Application no: H20-0617-10

Description: Erect 6 detached dwellings

Location: Off Bette Campling Close
Drawdike
Sutton St James
Spalding Lincs

Amendment: Amended site plan (Dwg no. 2038-09/01B)

Drawing
 LOCATION & SITE PLANS.

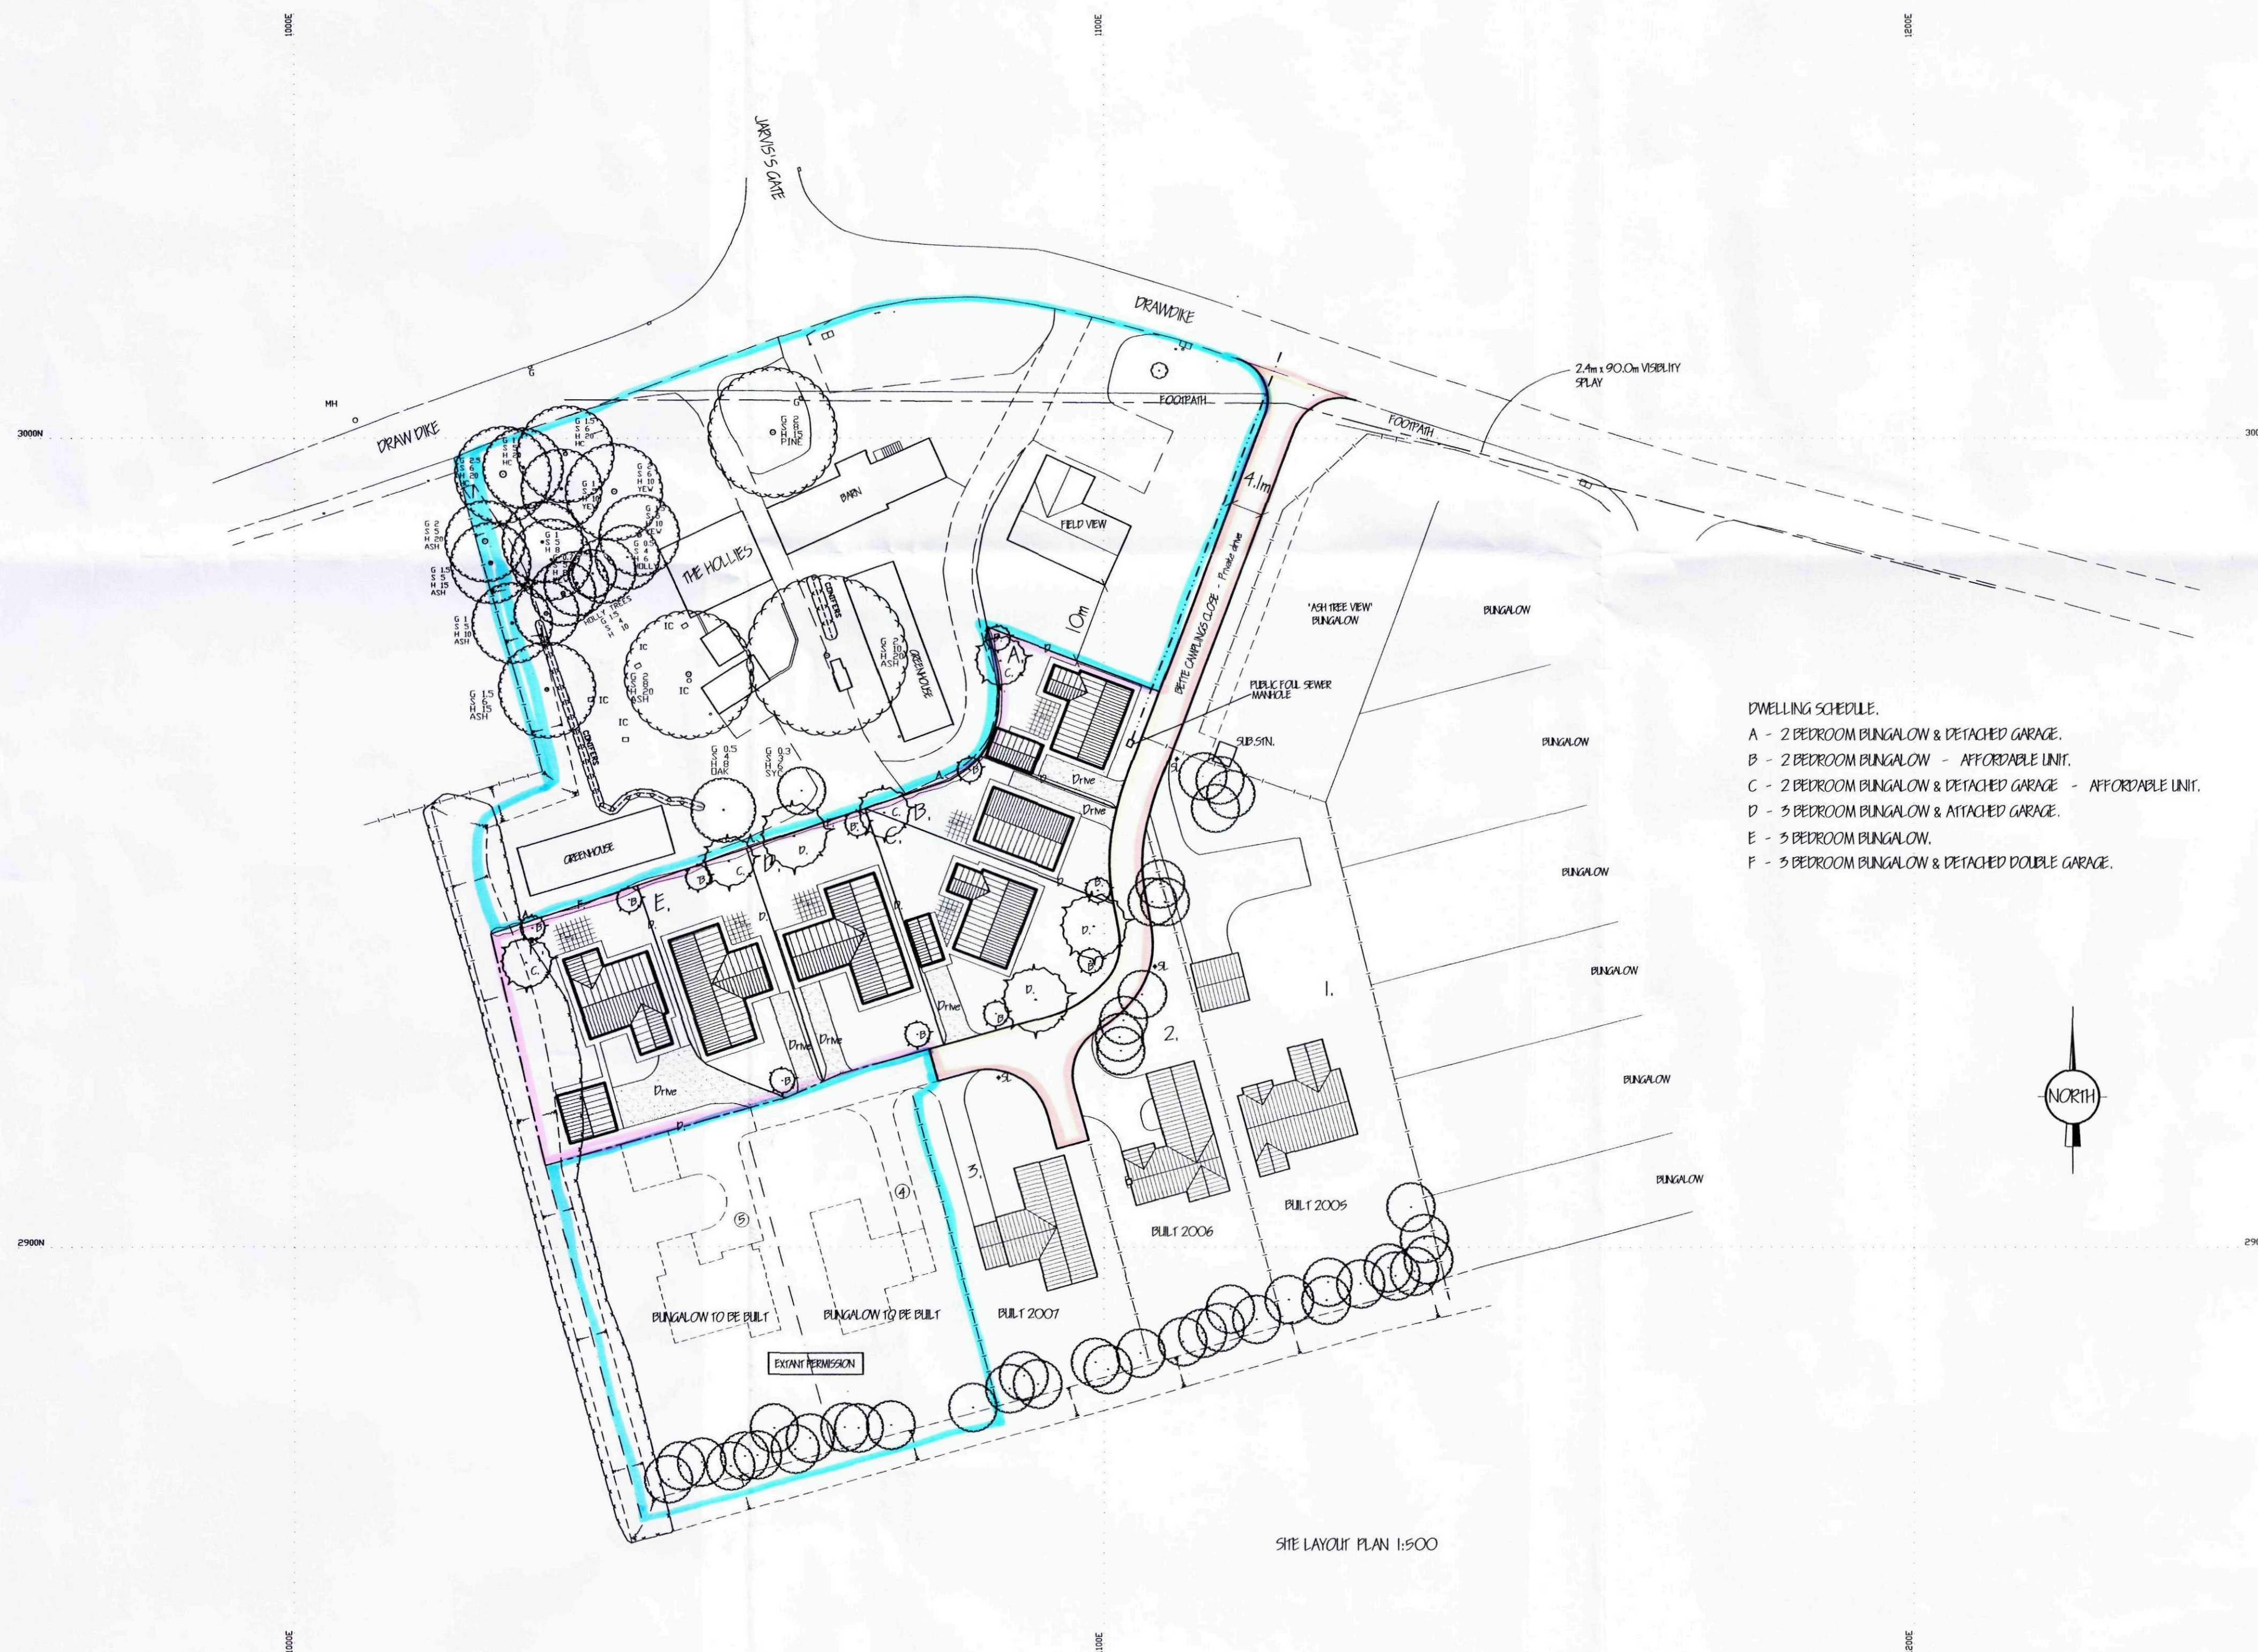
The boundaries shown between the entrance to Bette Campling Close and our property are incorrect; they should read as per the enclosed plan edged in red.

Please amend the development plans accordingly, and confirm to us before any decision is given on the application.
